RE: Redevelopment of Sydney Super Yacht Marina, Rozelle Bay – MP09_1065

Bruce Green
Executive Director
Maritime Property Strategic Development

Figure 2.1 Ground floor plan of proposal

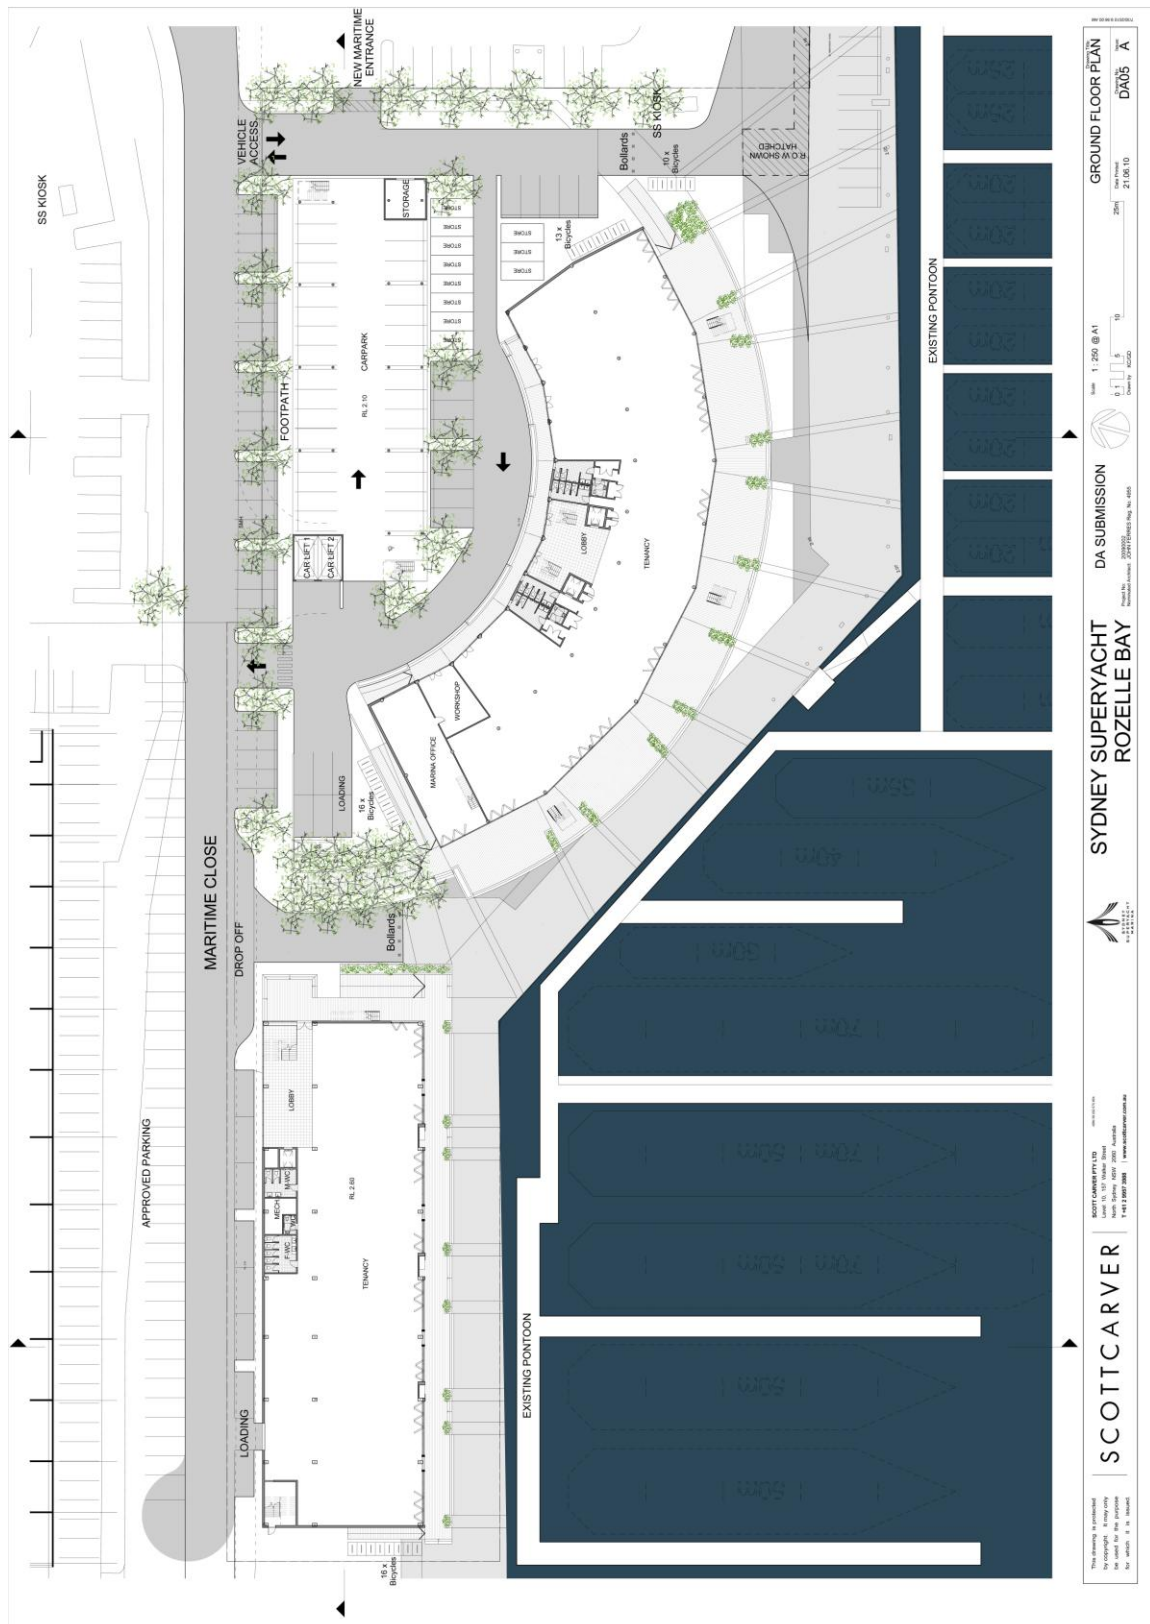
- The traffic circulation pattern shown on plans endorsed as part of any future consent should be made consistent with that shown in figure 2.1 on page 33 of the Environmental Assessment. This amendment is considered necessary to reduce the potential for queuing impacts outside the boundary of the property as a result of persons waiting to enter and/or exit the multi deck car park.
- That loading and unloading of vehicles associated with the ancillary operations and uses, with the exception of fuel tankers and vehicles delivering goods to berthed vessels, be restricted to the rear of all buildings.
